Application Ref: 68467/APP/2013/2063

REFUSAL OF PLANNING PERMISSION

Conversion of existing dwelling to form 1 x 3 bed and 1 x 1 bed dwellings with associated parking and amenity space (Resubmission)

Location of development: 20 Snowdon Crescent Hayes

20. SNOWDON CRESCENT, HAYES.
BLOCK PLANS (1:500) REV: JUN/13

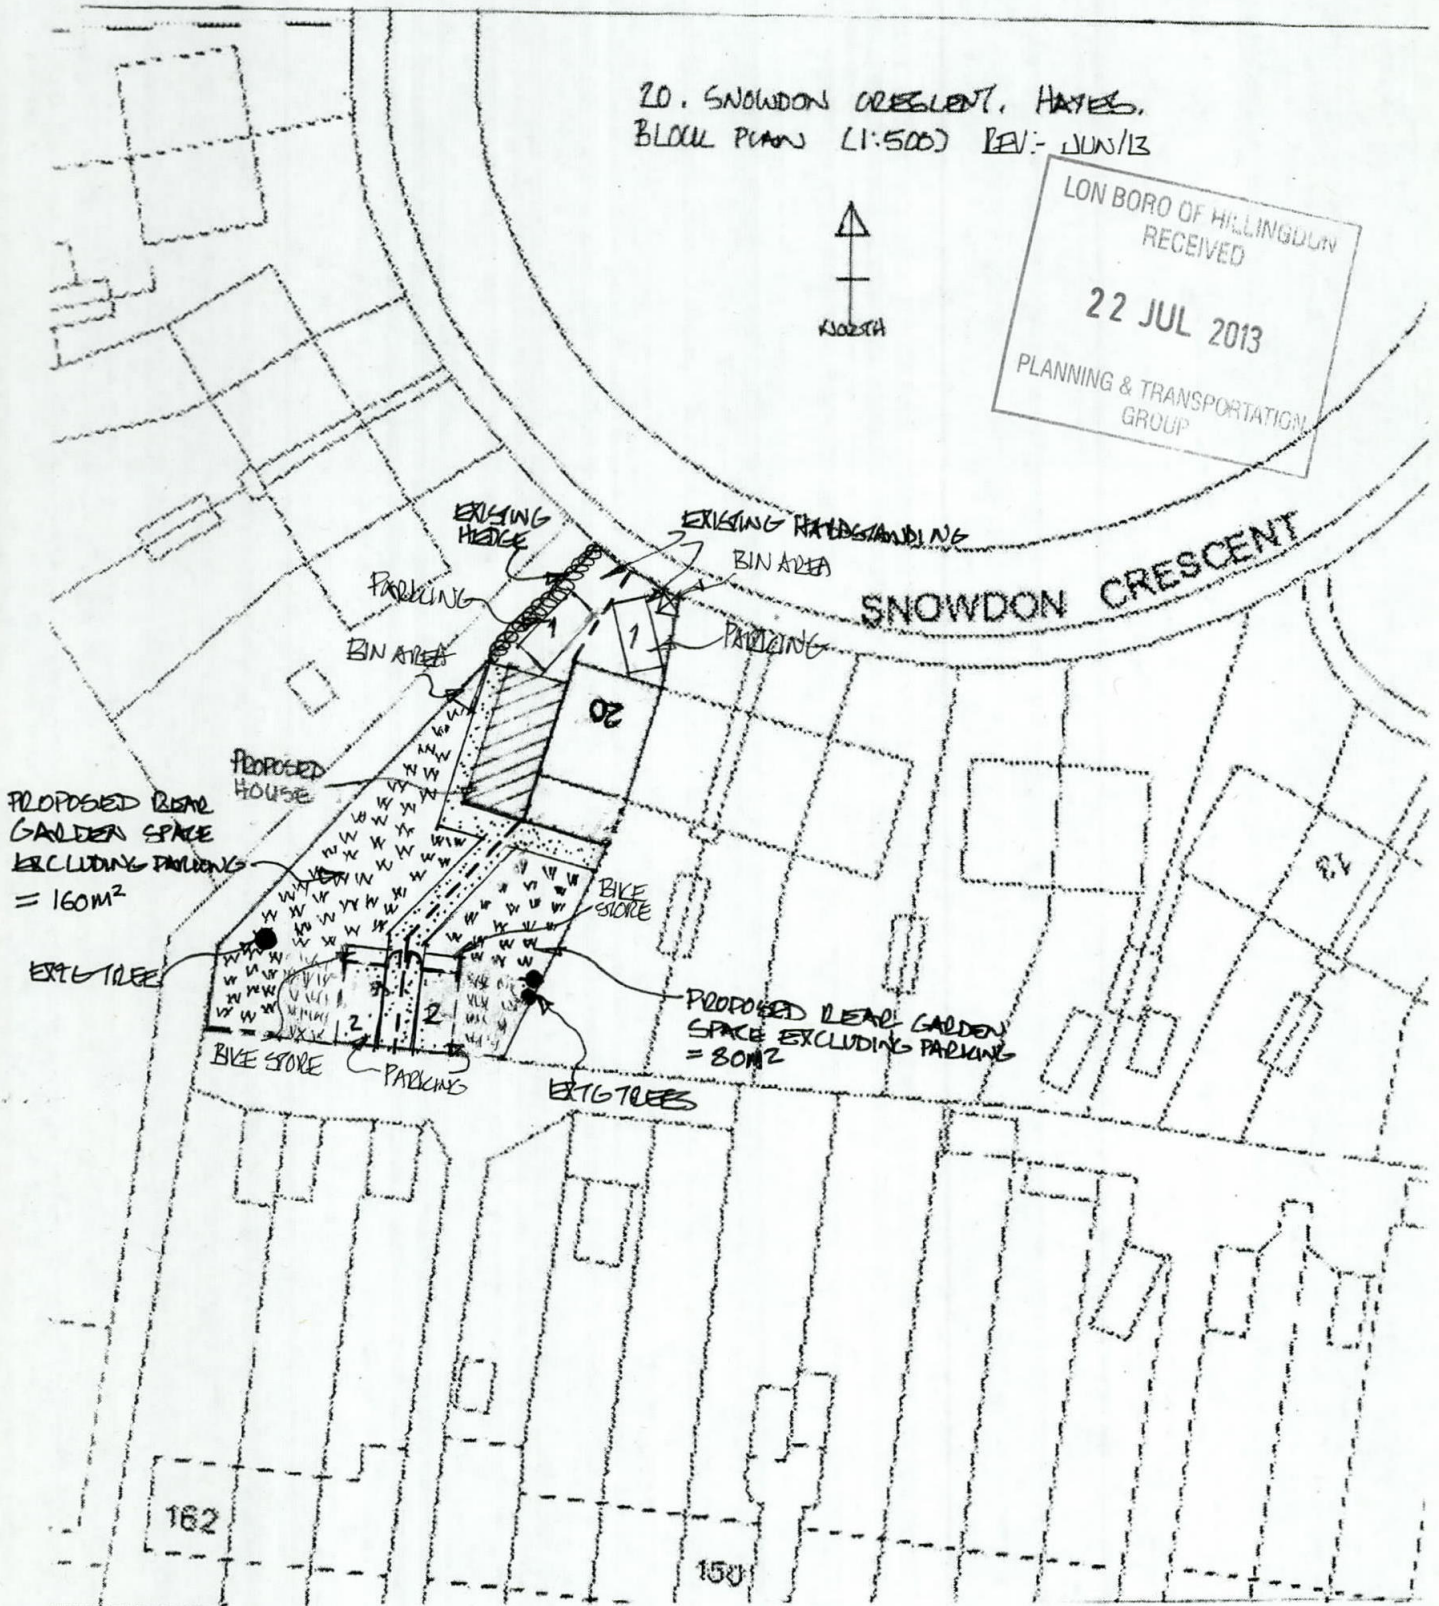
- 1 . The application fails to demonstrate that access could be provided to parking spaces proposed to the rear of the site, in addition, the location of the two proposed parking spaces to the rear of the site would result in the intensification of use of the existing sub-standard access from Bourne Road and as kerbside parking is permitted along the adjacent highway, visibility along Bourne Road would be obstructed by parked cars when entering and existing the access, to the detriment of highway and pedestrian safety. As such the proposal would be contrary to Policies AM7 and AM14 of the Hillingdon Local Plan: Part Two - Saved UDP Policies (November 2012).
